**Cheshire West and Chester Council's response to the
to the Applicant's comments to the Cheshire West and Chester Council's Local Impact Report (26 April 2023) [REP1A-004]**

Submitted at Deadline 3 – Tuesday 23 May 2023

This document represents a table of responses to Liverpool Bay CCC Limited ("the Applicants") response to Cheshire West and Chester Council's (" the Council")W Local Impact Report, in respect of the Applicant's application for development consent for the Hynet Carbon Dioxide Pipeline DCO ("the Project").

Figure 6.1 – Extract of the Ince Park Plastics Masterplan - Drawing Number: 20039-FRA-XX-00-DR-A-90-0005 P2 approved under application no. 21/04076/FUL and works no.3, EN070007-D.2.4-WP-Sheet 1 [AS-012].

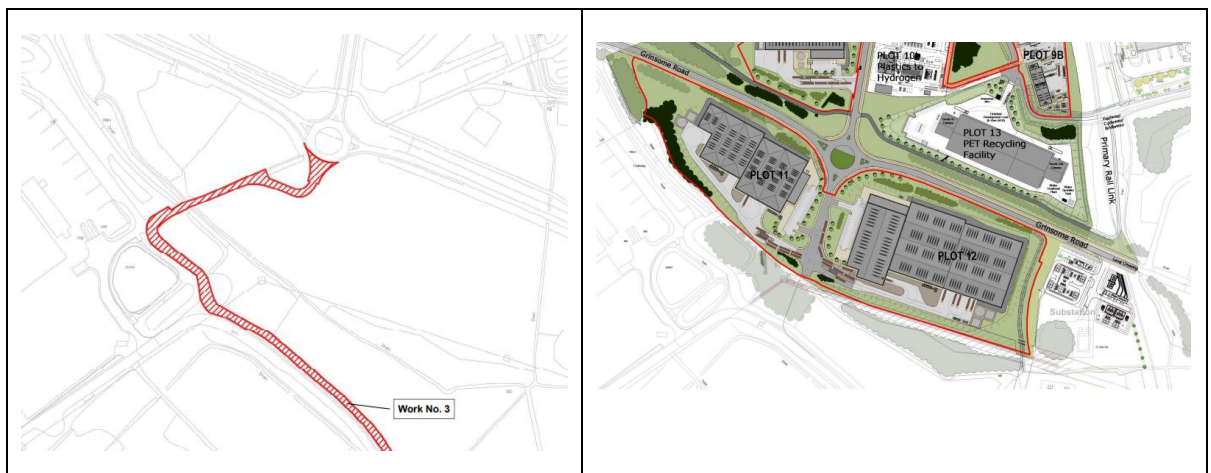
2.2.13	6.8	As part of the wider Protos (Ince Park) development, the masterplan of a recently approved Plastics Park (planning application no. 21/04076/FUL) shown in figure 6.1. Project 'work.no3' runs directly through plot 11 and building of the approved plastics park masterplan see figure 6.1 below, effectively sterilising this part of the site.	The Applicant acknowledges the potential for future delivery of the Protos Plastic Park (CWCC reference: 21/04076/FUL) and Protos Railway Line (CWCC reference: 10/01488/FUL, amended by CWCC reference: 14/02277/S73). The combined and cumulative effects of the DCO Proposed Development and the Protos Plastic Park (CWCC reference: 21/04076/FUL) have been assessed within Chapter 19 - Combined and Cumulative Effects of the 2022 ES [APP-071] and of the Environmental Statement Addendum Change Request [CR1-124].

2.2.14	6.9	<p data-bbox="578 682 1181 850">By sterilising part of approved development which falls within an area safeguarded for economic / employment uses in the LDP, the Council highlights the Project's potential for adverse local economic impacts.</p>	<p data-bbox="1240 682 1955 745">The Applicant refers CWCC to the responses 2.2.10 to 2.2.13 above.</p>	 <p data-bbox="1979 1272 2745 1339">Extract from Proposed Site Plan 12473-AEEX-XX-DR-A-0501 Rev P23 of application no. 22/03693/FUL</p>

Reference	LPA Reference	Local Impact Report (Deadline1A)	Applicant's Response (Deadline2)	Council's Response (Deadline 3)
				 <p data-bbox="1982 1287 2650 1360">Work No.3, EN070007-D.2.4-WP-Sheet 1 (Rev D) [REP2-005].</p> <p data-bbox="1982 1392 2745 1493">The Council would welcome engagement and constructive dialogue from the Applicant in respect the impacts of the proposed permanent access (Work No. 3).</p>
